From: Anita Gardner
Sent: 16 March 2017 17:05
To: Karen Parsons
Subject: FW: White Lodge Rectory Lane Angmering - A/207/16/HH and A/208/16/L

From: [REDACTED]
Sent: 07 March 2017 16:24
To: Anita Gardner
Subject: White Lodge Rectory Lane Angmering

Drawing Proposed Extension
First Floor and Roof

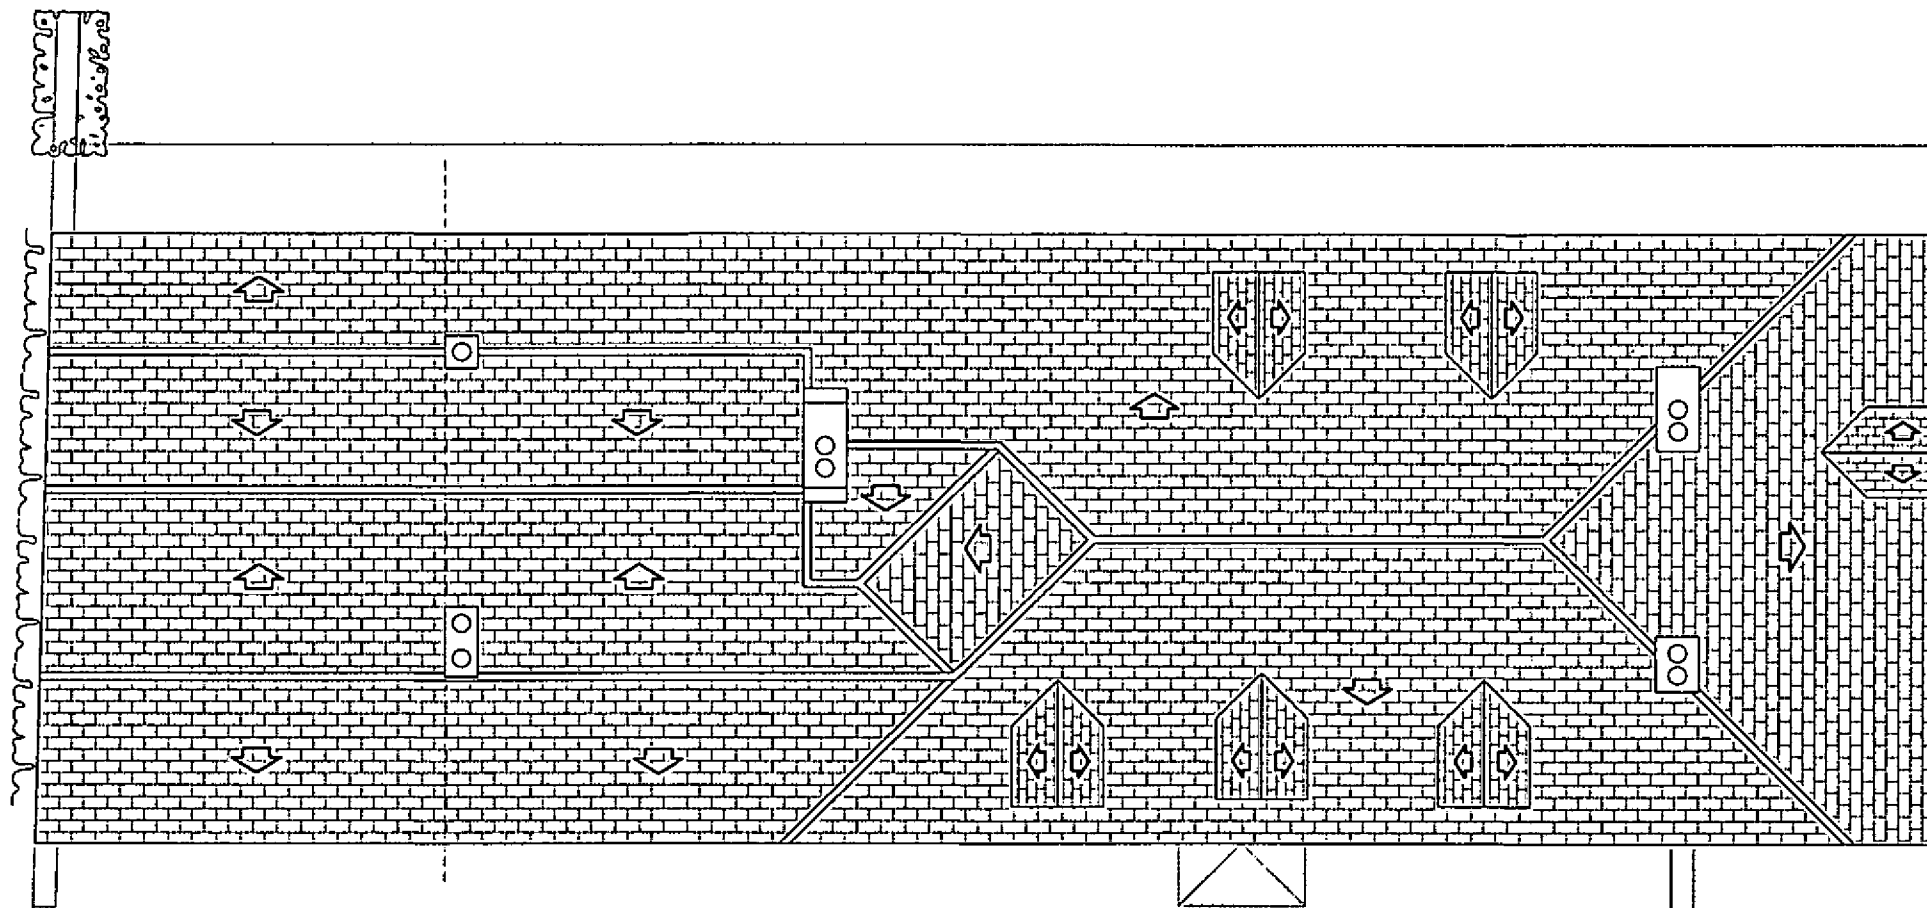
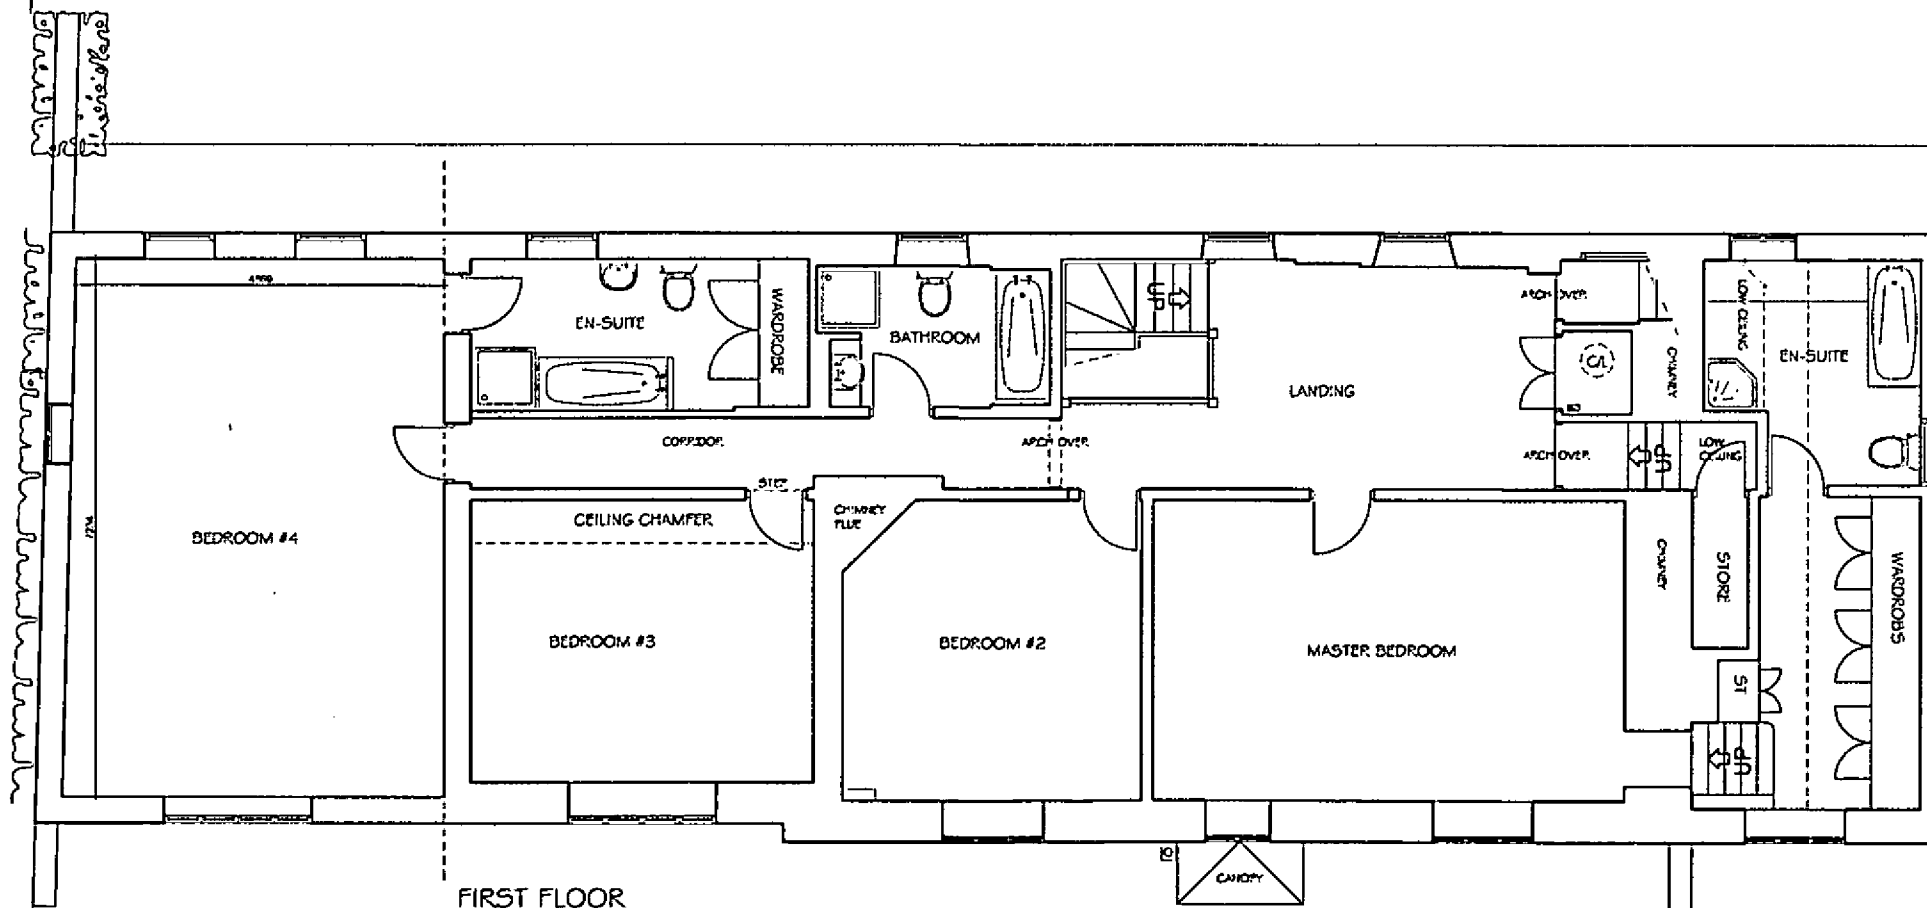
He has advised that he would be unlikely to support either proposal. The proportions and design of the single storey extension are considered inappropriate for the existing building they should be of a lighter construction and have a sloping roof to reflect the design of the opposite end of the dwelling and take the form of a glazed timber conservatory which is set in from both front and rear elevations. The opening up of the ground floor layout and complete removal of the end elevation of the property without retention of at least nibs would not be acceptable and would be deemed to adversely affect the character of the listed building.
